BOLTON-BY-BOWLAND, GISBURN FOREST & SAWLEY PARISH COUNCIL

OBSERVATIONS ON PLANNING APPLICATION REQUIRED BY

PLANNING APPLICATION NO: 0774

RELATING TO LOWER MONUMENT FARM BARN

PROPOSED SOLAR PANEL LAYOUT PLAN

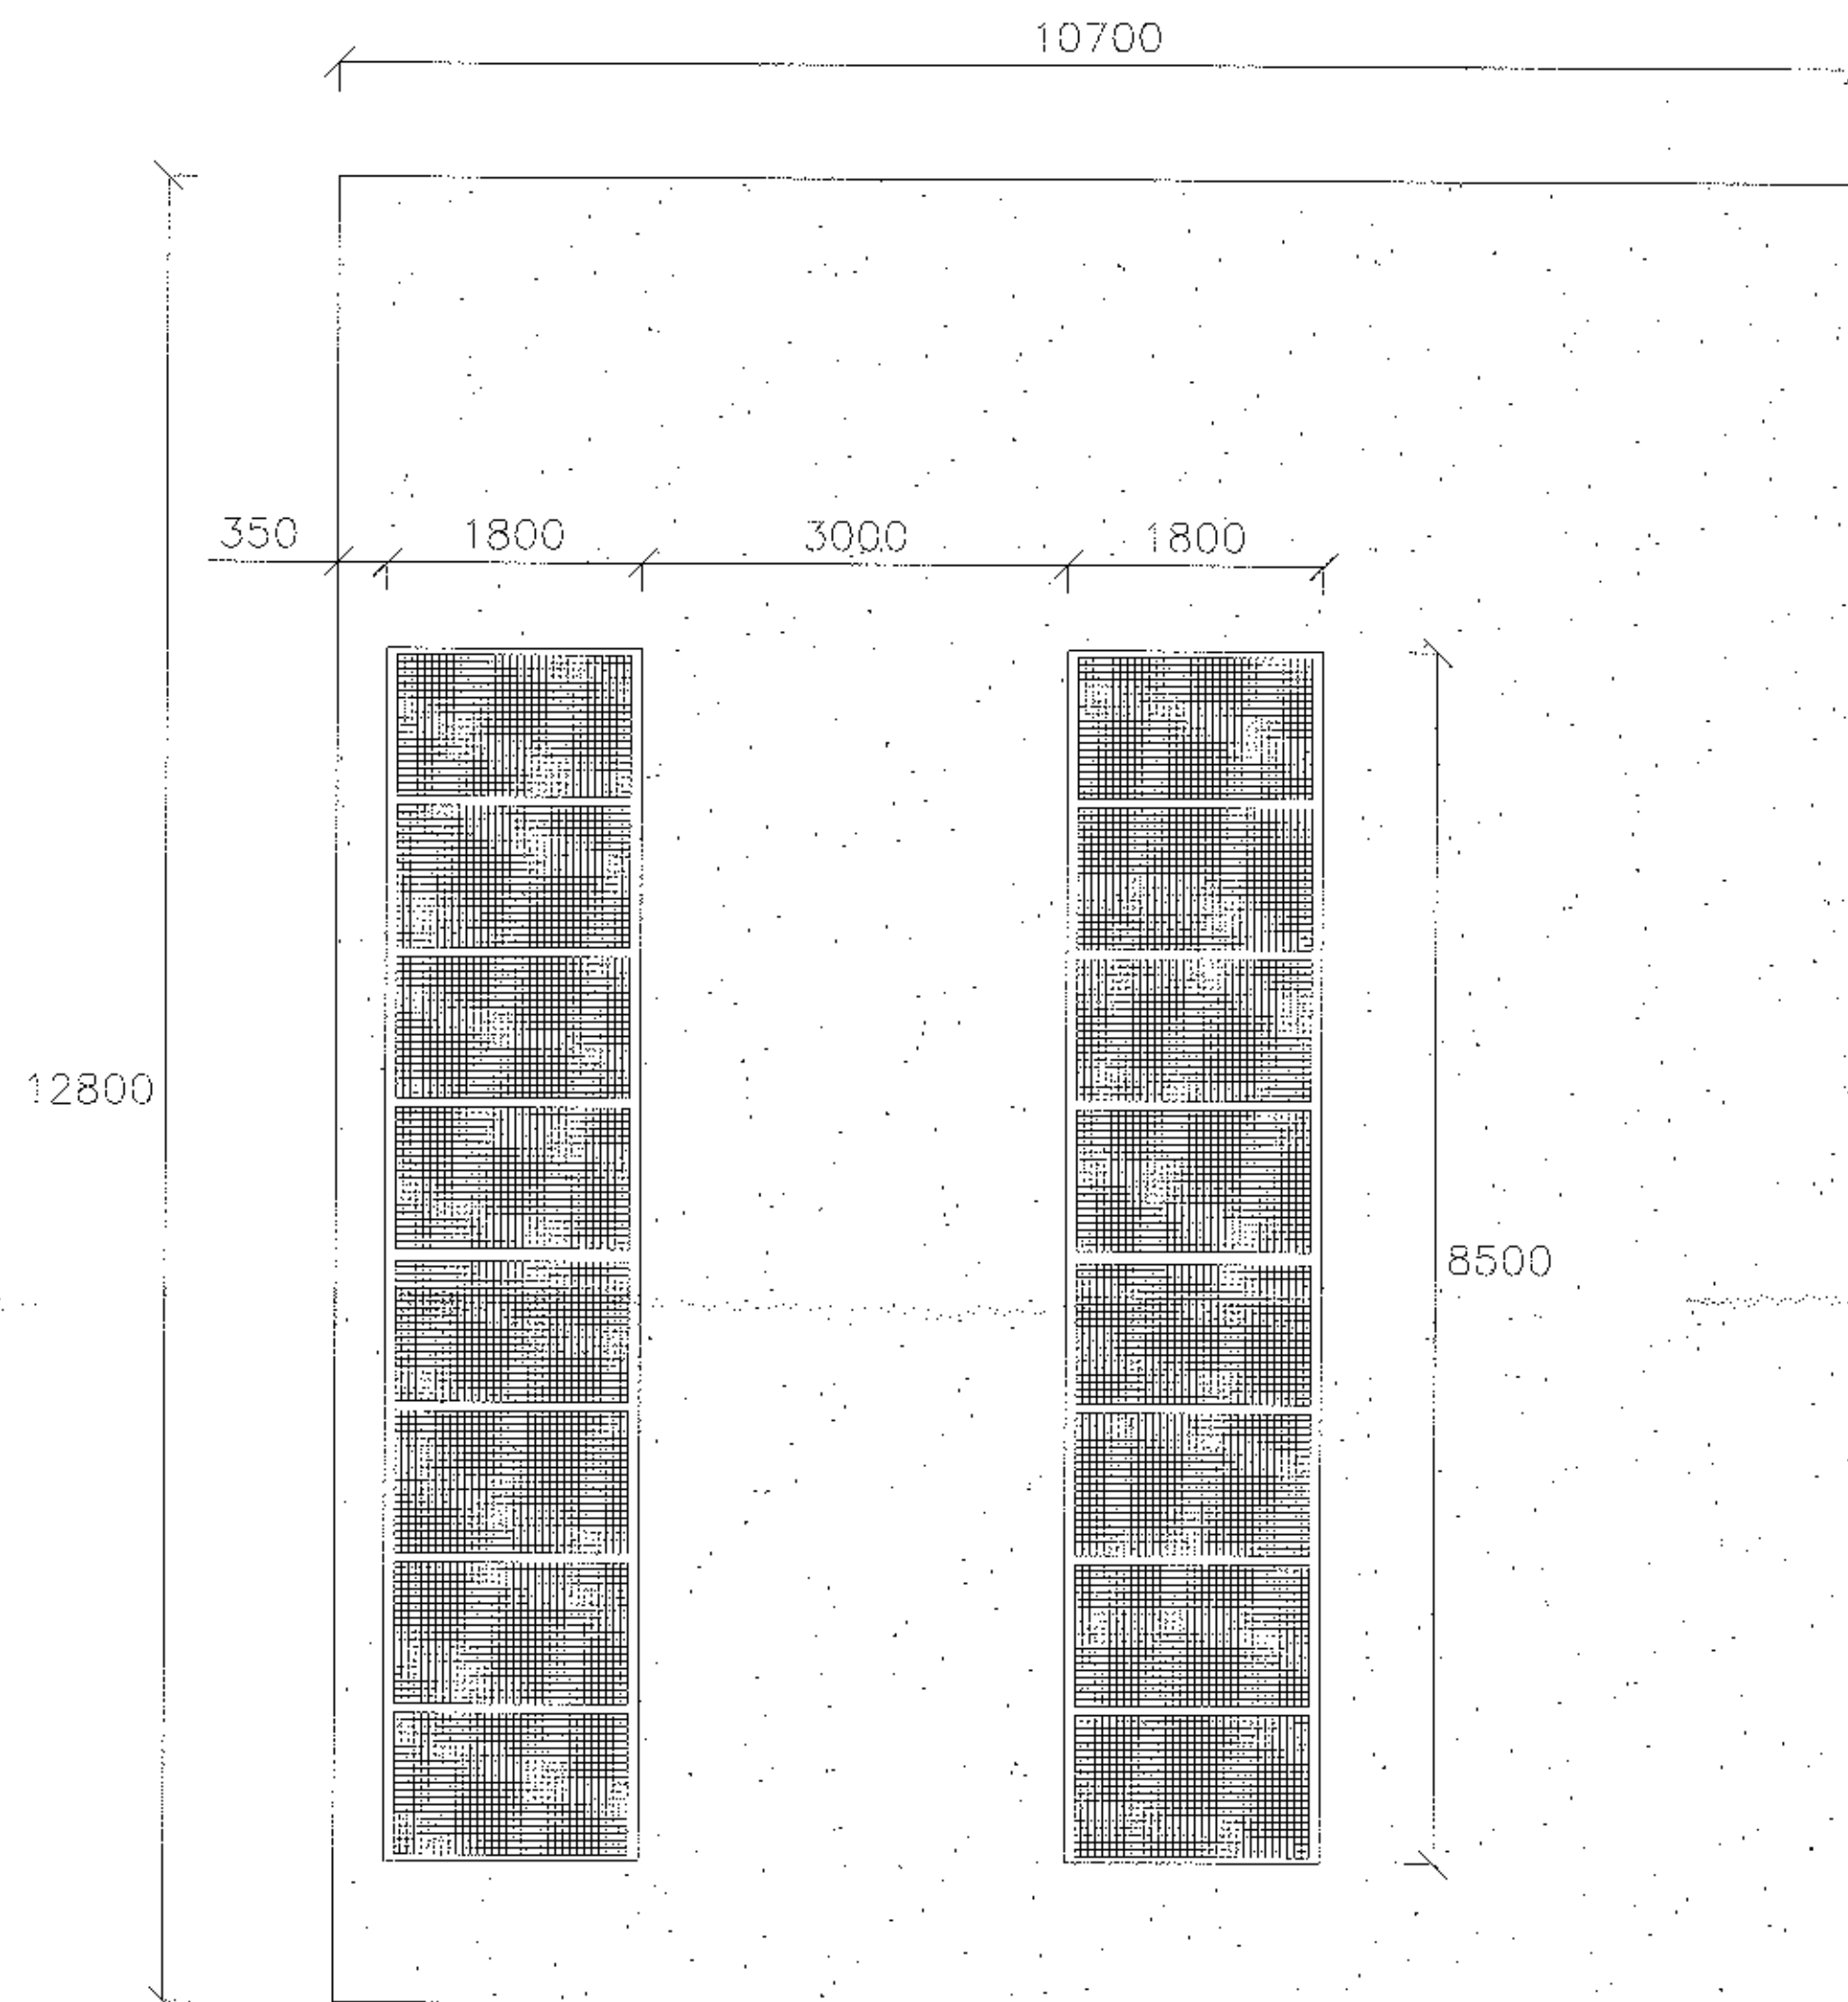
*NOT SURE ABOUT SOLAR PANELS IN
FIELDS IN AONB*
